Statement of Common Ground with Beverley and North Holderness Internal Drainage Board (draft)

Revision 2

September 2025

- 1.1.2 The DCO Application is for a Nationally Significant Infrastructure Project (NSIP) for the construction, operation (including maintenance) and decommissioning of a solar photovoltaic (PV) array electricity generating facility, Battery Energy Storage System (BESS) and associated infrastructure which would allow for the generation and export of electricity.

Temporary bridges - General arrangement

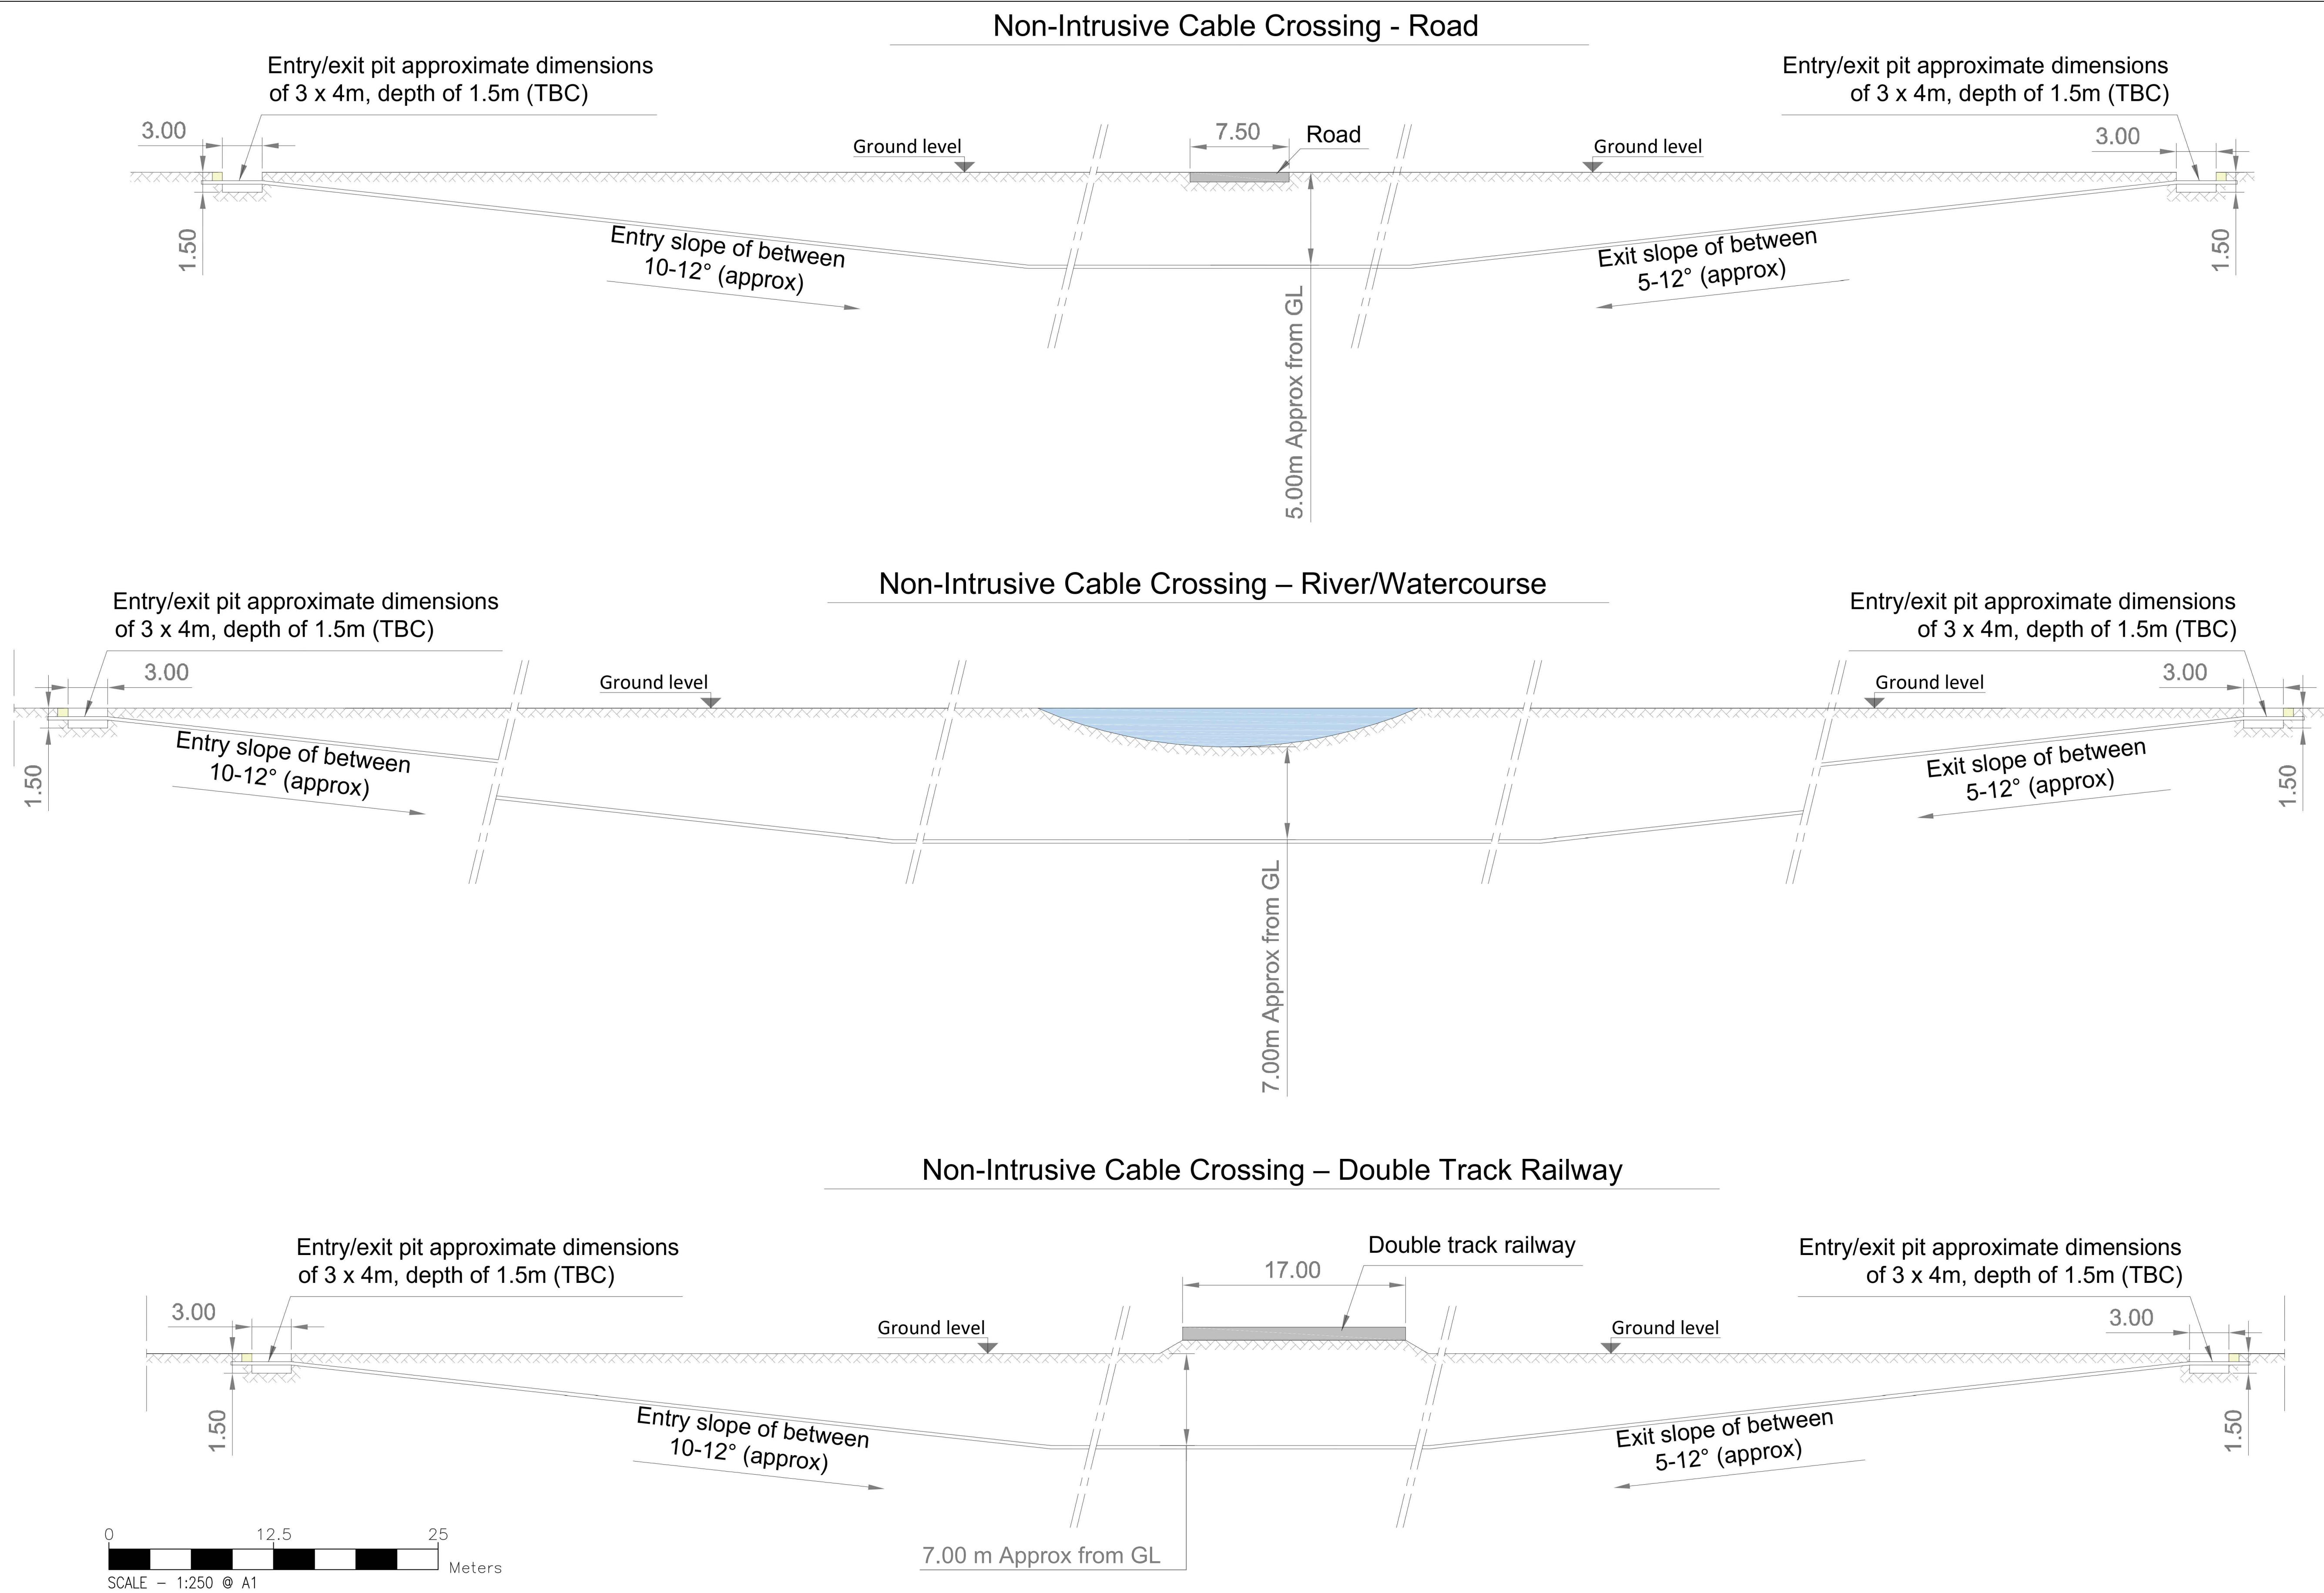
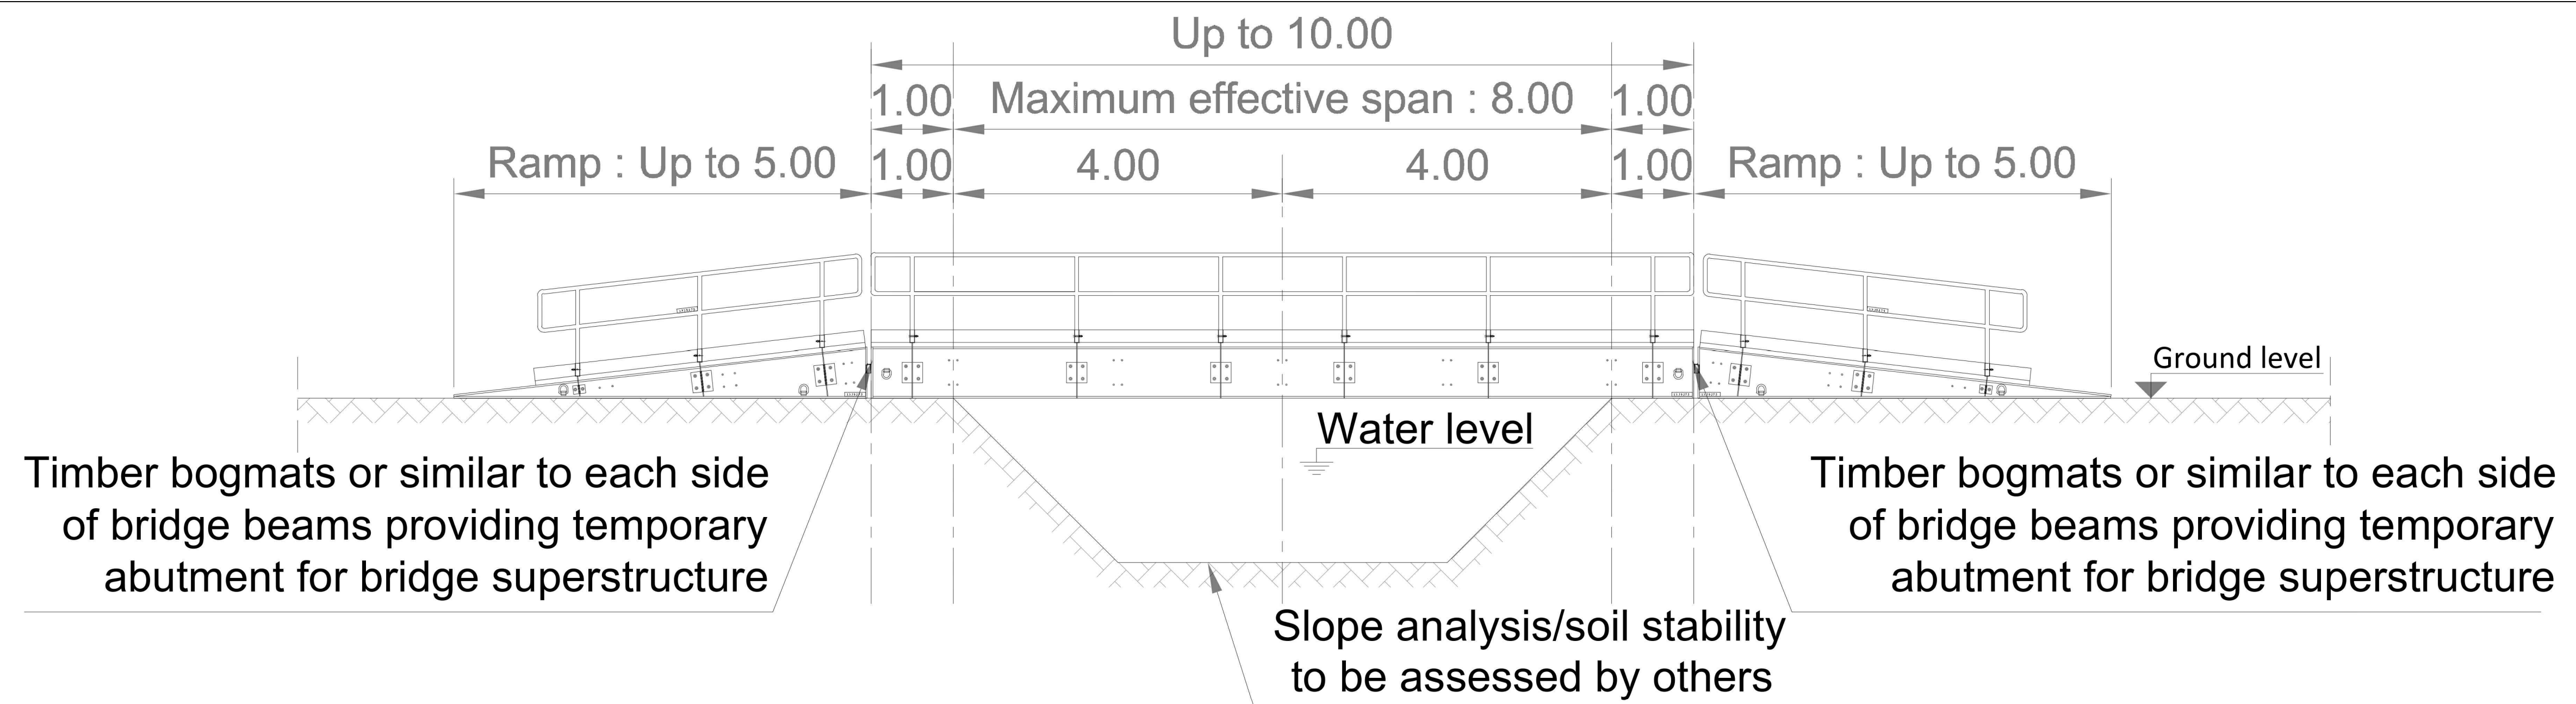
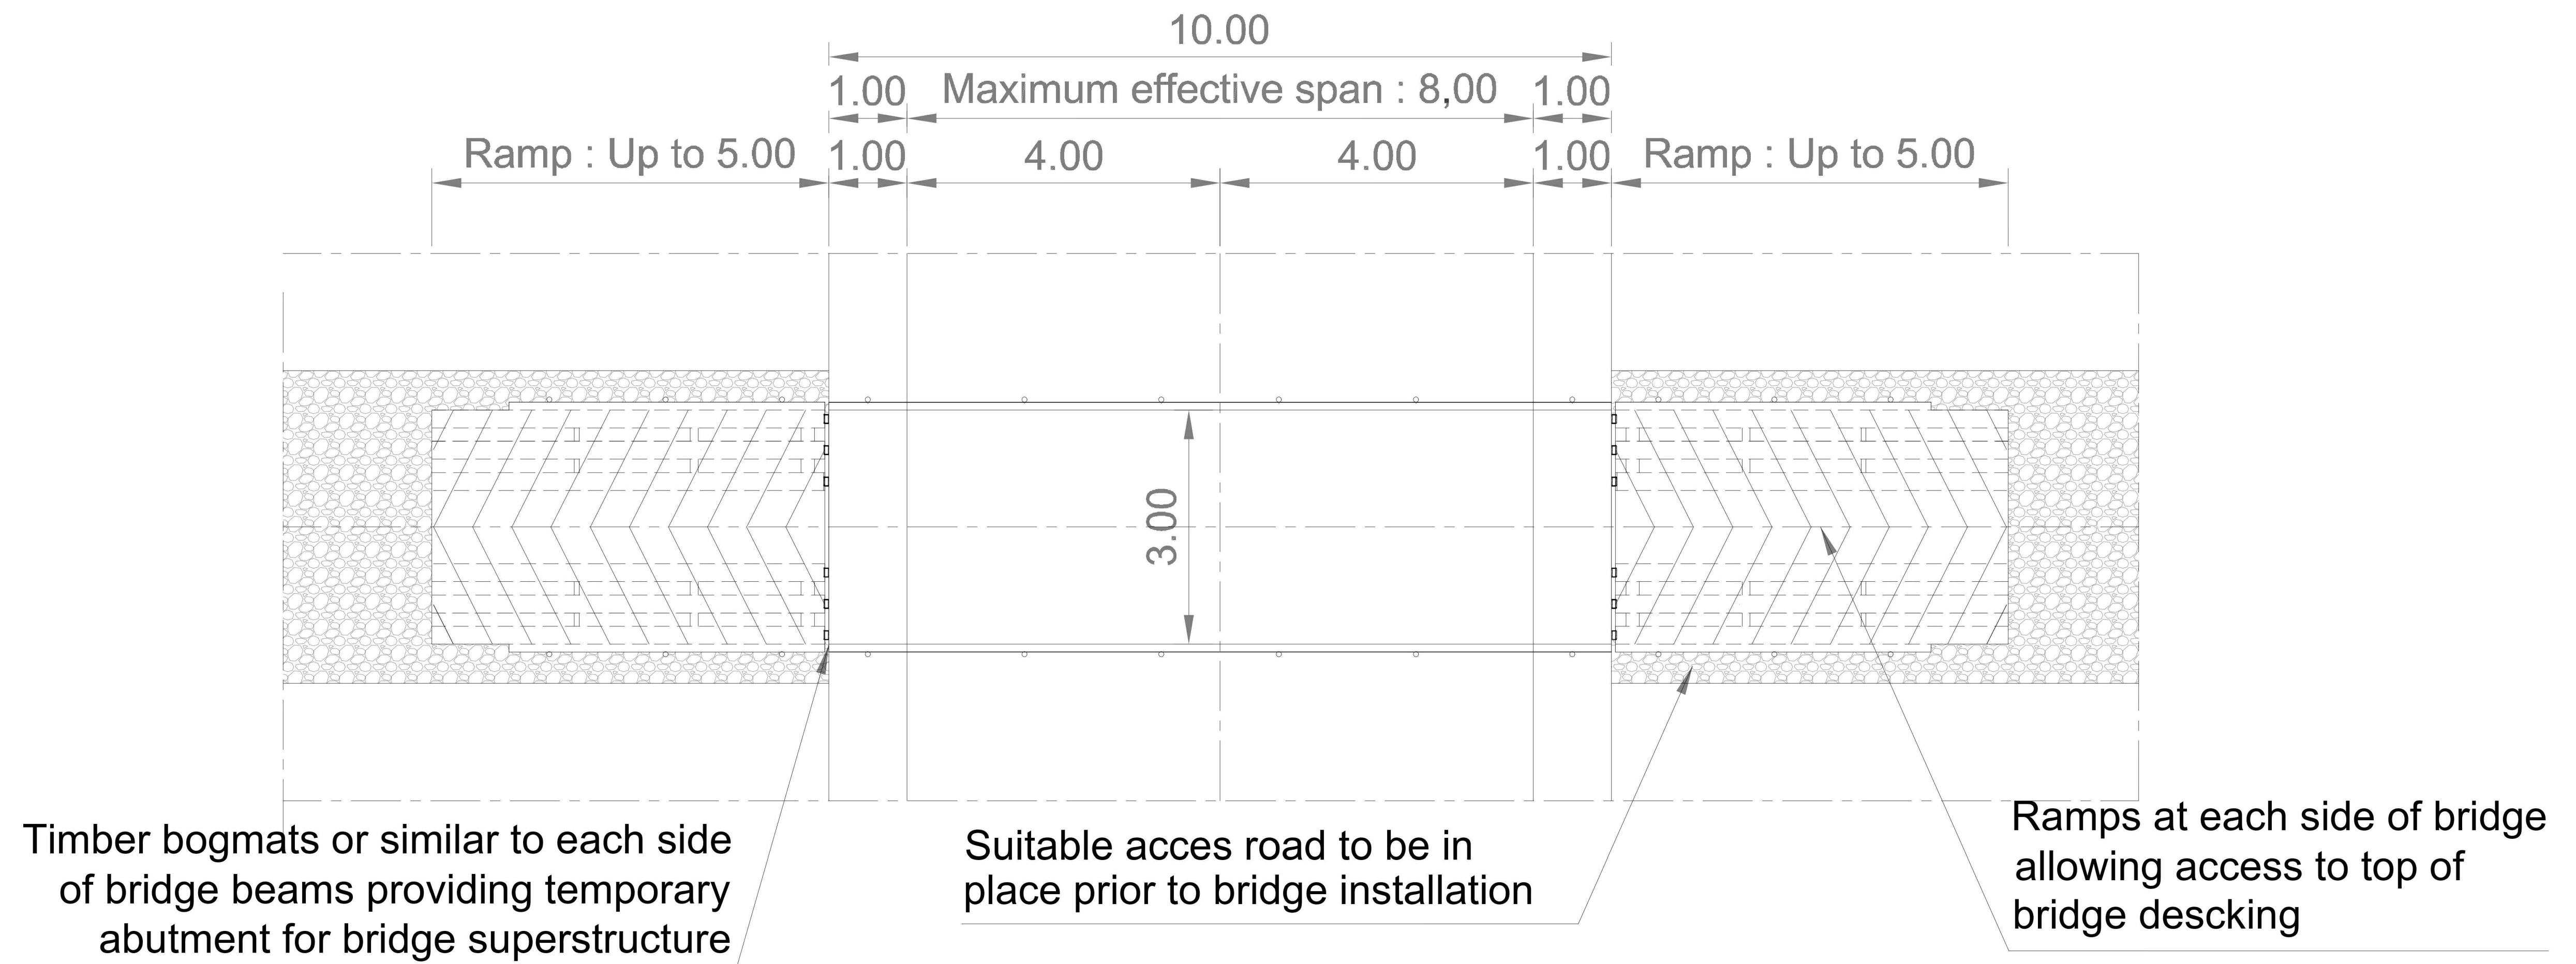
Ref	Topic	Beverley and North Holderness Internal Drainage Board Position	Applicant's Position	Status
	crossings over watercourses <i>Hydrology and Flood Risk</i>	Drainage Board requests that details of any bridge/ culvert crossings over any watercourses within its district will need to be discussed and agreed with the Board.	crossings and/or bridge structures where possible. Pre-construction structural surveys will be undertaken to determine the most appropriate crossing at each location (it is expected that the pre-construction surveys would result in the number of new crossings required to be lower than is shown on ES Volume 3, Figure 3.6: Indicative Culvert Crossing Points [APP-060]). Crossing design would be controlled by the protective provisions within Part 3 of Schedule 12 to the Draft DCO [EN010157/APP/3.1 Revision 4] , which require plans to be submitted to the Board for approval at the detailed design stage. ES Volume 4, Appendix 5.6: Flood Risk Assessment [EN010157/APP/6.4 Revision 3] and ES Volume 4, Appendix 5.5: Water Framework Directive Screening and Scoping report [EN010157/APP/6.4 Revision 2] have been updated to clarify the approach to watercourse crossings and are submitted at Deadline 1.
